Item No. **Report of the Interim Director of Planning, Regeneration & Public Realm**

Address 13 RUSHDENE ROAD EASTCOTE PINNER

Development: Erection of single storey extension to front, side and rear following demolition of existing garage

LBH Ref Nos: **32287/APP/2022/2394**

Figure 2

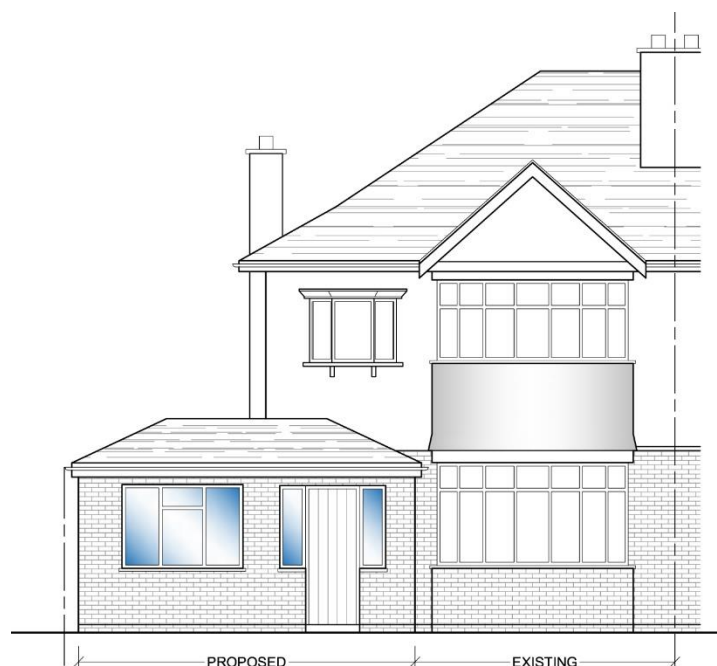
Whilst the width of the side extension and depth of the rear extension are considered acceptable, concerns are raised in terms of the forward projection of the side extension and its impact on the architectural integrity of the host dwelling and streetscene. The proposed front extension would extend out the level of the bay window and would fail to relate satisfactorily to the host dwelling and would unbalance the visual symmetry of the pair of semis. The side/front extension would fail to appear as a subordinate addition and would represent an incongruous addition to the streetscene in conflict with Policy BE1 of the Hillingdon Local Plan: Part One Strategic (2012) and Policies DMHB 11, DMHB 12 and Policy DMHD 1 of the Hillingdon Local Plan: Part Two - Development Management Policies (2020).

The policy for front extensions is clear and the proposal fails to comply as it would:

- alter the overall appearance of the house
- dominate the character of the street
- fail to be subordinate in scale
- not be designed to respect the character and features of the original building.

Importantly, revisions were sought during the course of the application to set back the side extension in line with the main front wall of the house and retain a porch of a reduced width, that did not wrap around. Revisions were not received.
